## Re: Peer Review of the Economic Assessment (cost benefit analysis) and Economic Assessment (macroeconomic analysis) of the Santos NSW (Eastern) Narrabri Gas Project

I have now completed my draft review of the reports entitled 'Narrabri Gas Project – Environmental Impact Statement Economic Assessment' prepared by GHD and 'Narrabri Gas Project Economic Impact Report' prepared by ACIL ALLEN Consulting. My draft review of these reports is based on versions that that are dated August 2016.

## Introduction and background

Figure 2 Narrabri Shire and Narrabri and surrounds location

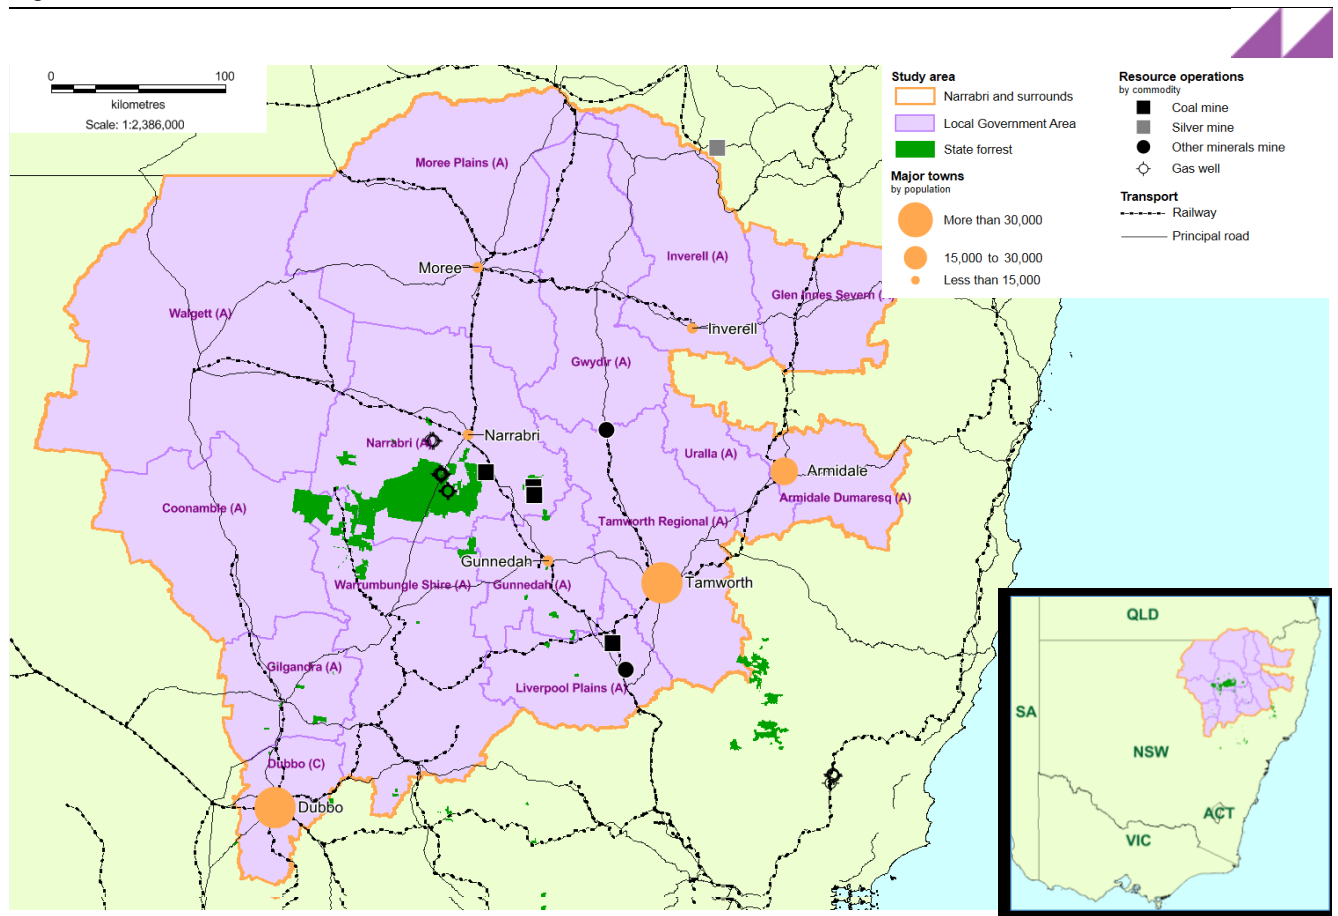
have been carefully done and gives plausible estimates of the likely impacts of the project (given the assumptions made). However, under the guidelines, the 'locality' for the purposes of completing the local effects analysis is defined as the Statistical Area Level 3 (SA3). It is often the case that a project's location and its 'connections' with the local community may not fall neatly within a given SA3 in which case analysis would be conducted and presented in the report to justify the choice of an alternative definition of the 'locality'. The ACIL ALLEN report does not contain such analysis and it is not clear why the consultant chose the regions as defined rather than the Narrabri-Moree SA3 in which the project is located.

It is understood the intention of *The Guidelines* is to require an examination of how local people who may experience changes incurred from the project would be affected. As the project is located towards the southern extremity of the Moree – Narrabri Statistical Area 3, it was decided, consistent with the approach taken in similar projects<sup>1</sup>, that the intent of *The Guidelines* would be best fulfilled by constructing a larger, custom locality that reflects the wider area likely to be affected by a project of this nature.

The 15 LGAs are shown on Figure 1, below, which also shows their spatial relationship to the Statistical Areas - Level 3, including the Moree-Narrabri Statistical Area – Level 3.
